This representation was made at the Boreas Specific Issues Hearing held on 13 November 2019 in Norwich.

The Parish Councillors of Necton unanimously believe that given the constraints listed below, the small quiet, rural parish of Necton is not the ideal or even the best location for this massive industrial development given that an off-shore ring main option is under review by the government and would be a much more suitable GRID connection method. However, if this is not an option, the following issues should be addressed by the project:

Title:
Environment Agency flood zones map

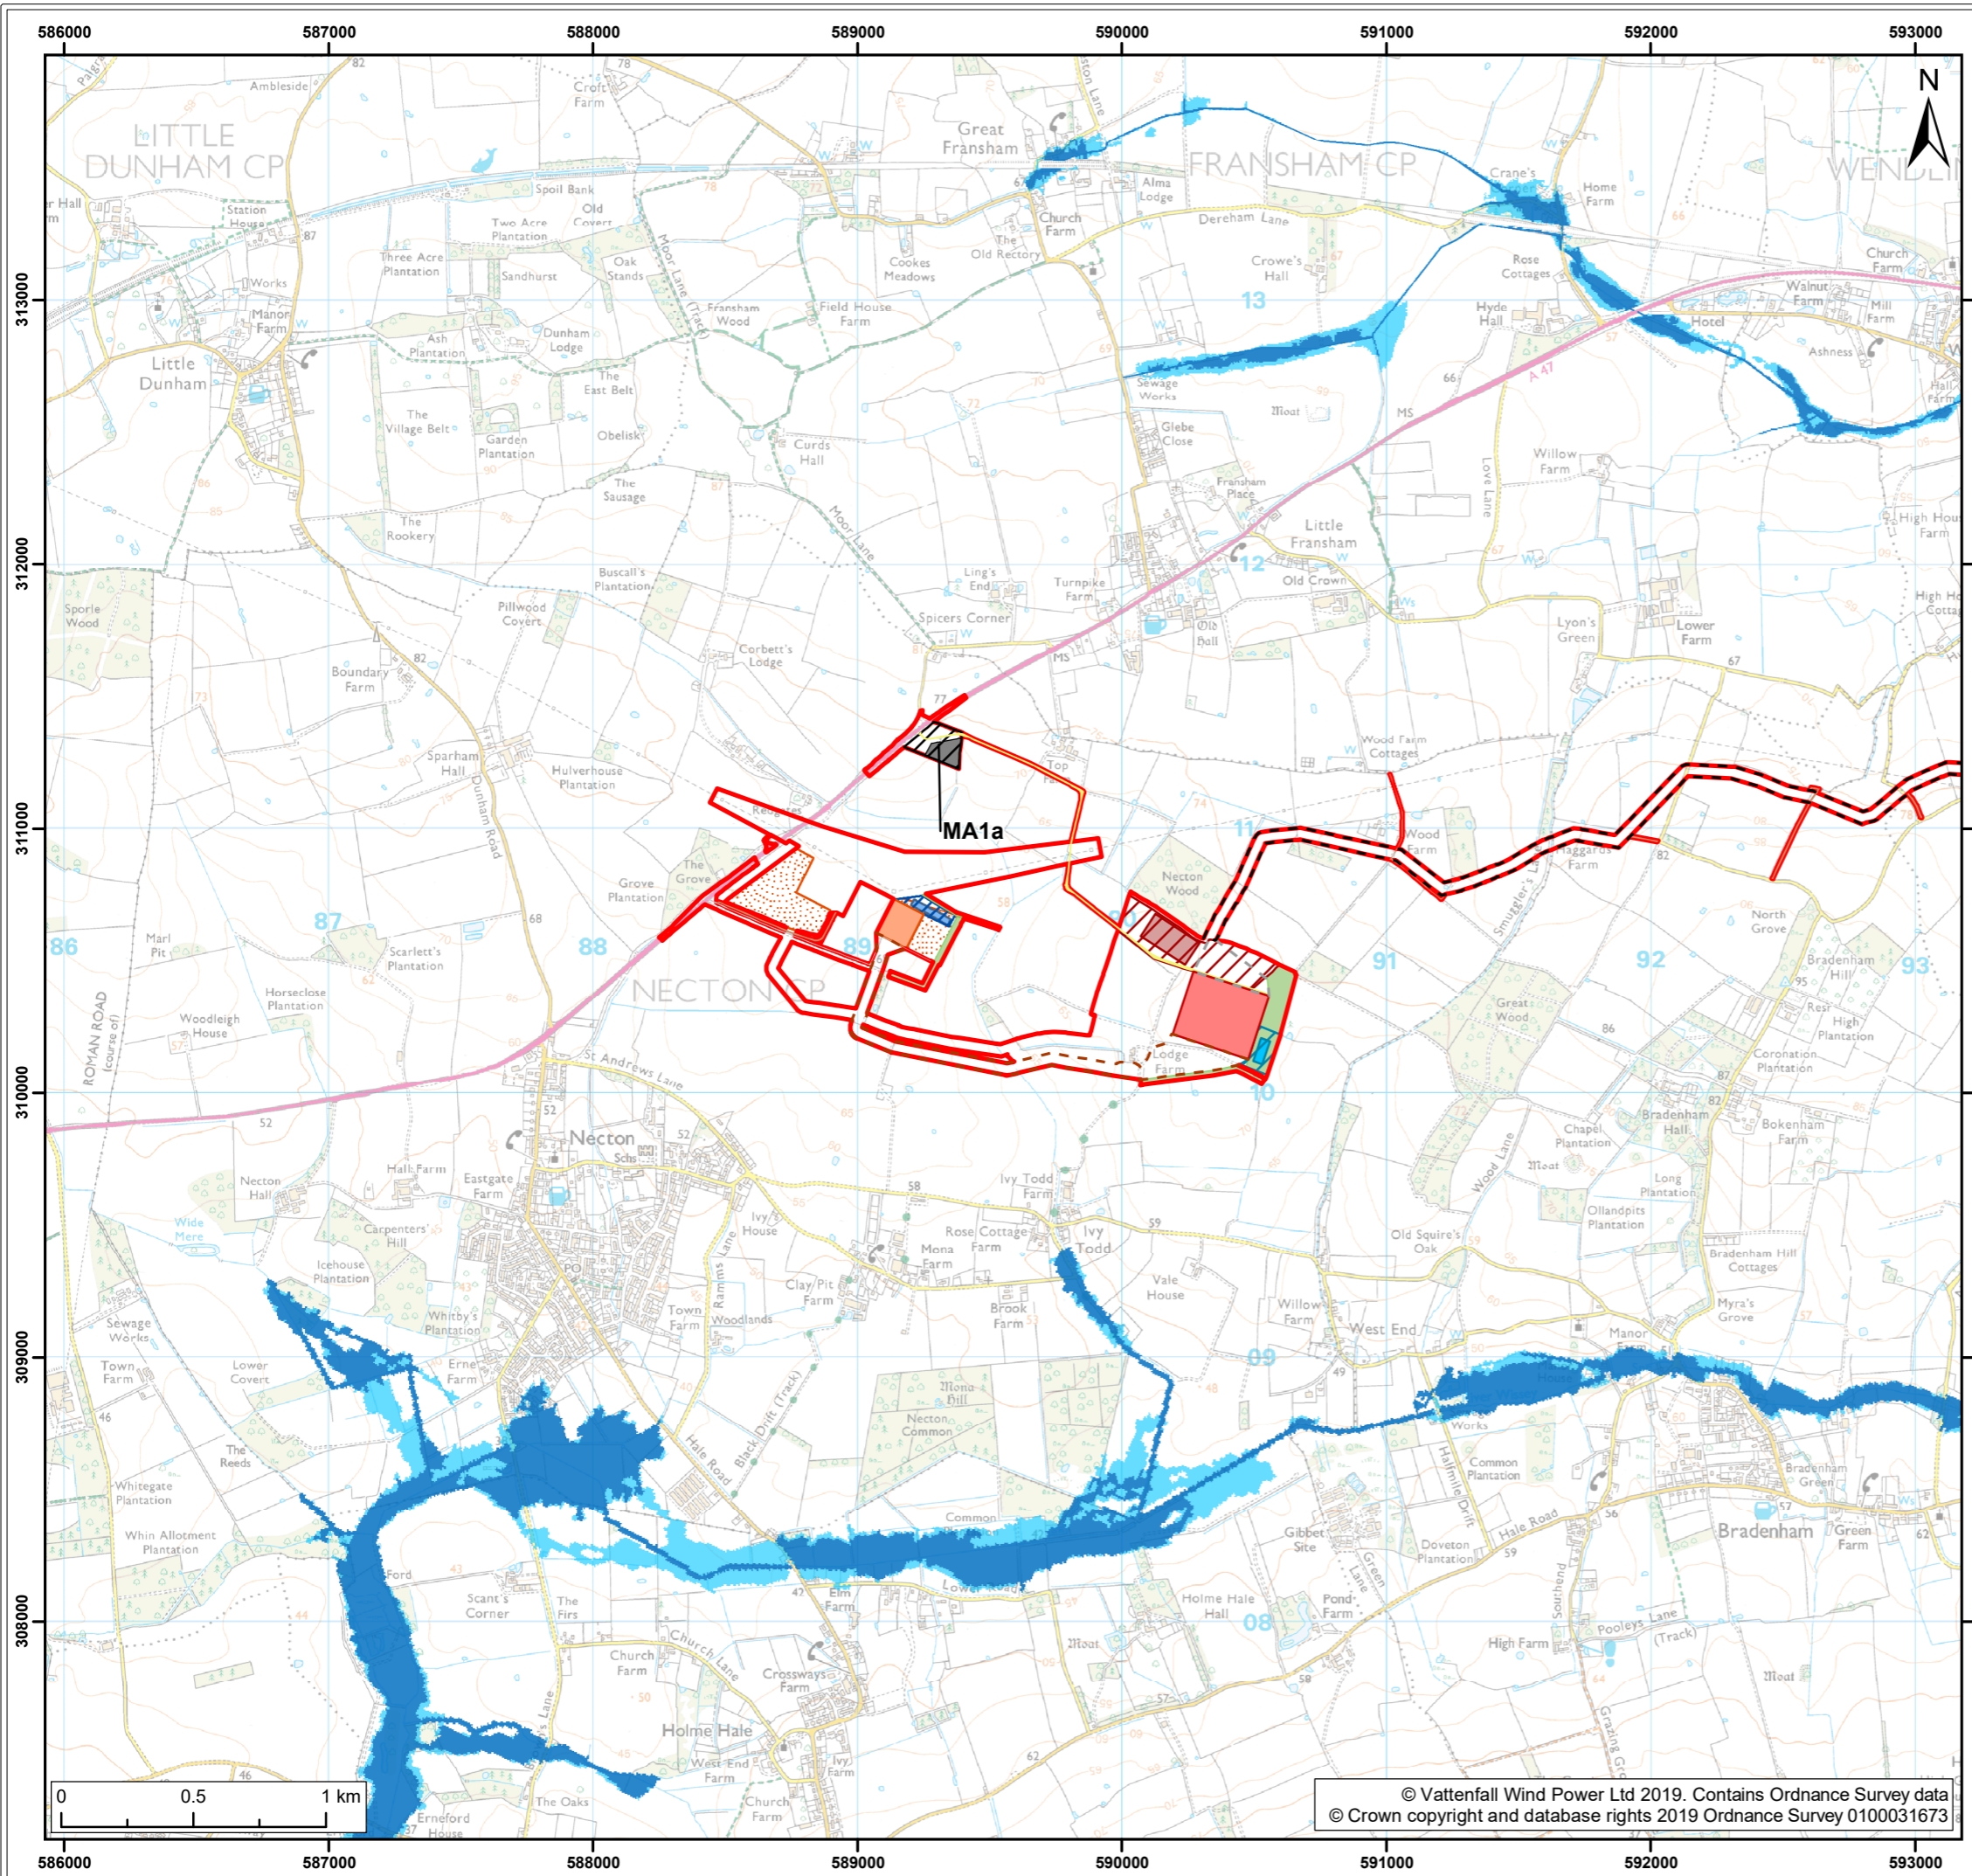
- 1) The Boreas proposed substation site is capped by a thick layer of impervious clay that soon defies any attempts at drainage other than the natural topography via a small stream that becomes a raging torrent within minutes of any storm. It floods the road downstream, blocking the 4" culvert and flooding the nearby properties. This needs to be addressed by the Boreas project proposal.

Title:	Scenario 1 Viewpoint 4: A47 Necton Substation
--------	---

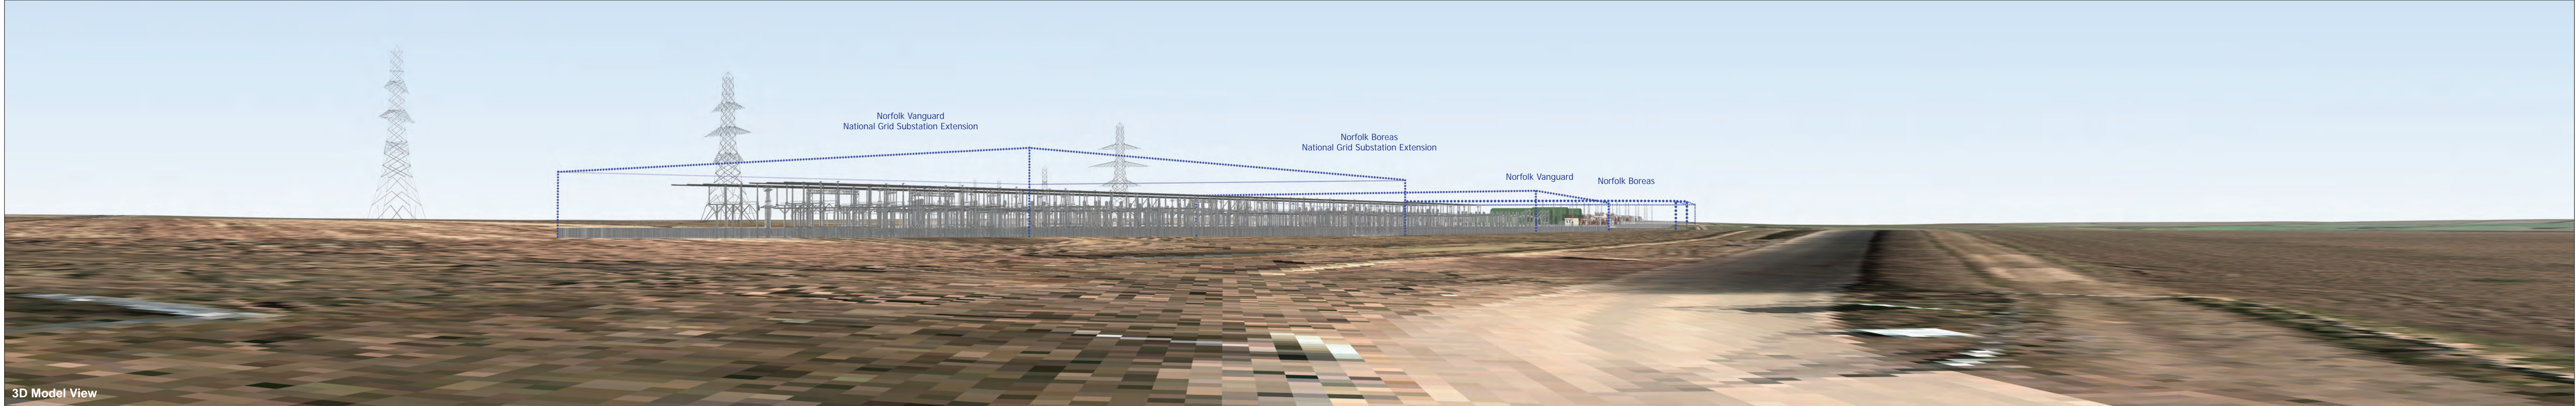
- 2) Due to the elevation of the proposed site, the highest in the Parish, it will be impossible to screen the industrial development from view and avoid the light pollution from the many very high buildings planned. The proposed mitigation measures will not be effective for many years, if ever. More adequate mitigation should be planned that might include an earth bank or lowering the ground level of the buildings. Moving the buildings to Top Farm is the preferred option because this site is approx. ten metres lower in height and free of the debris from the 1996 RDAF crash.
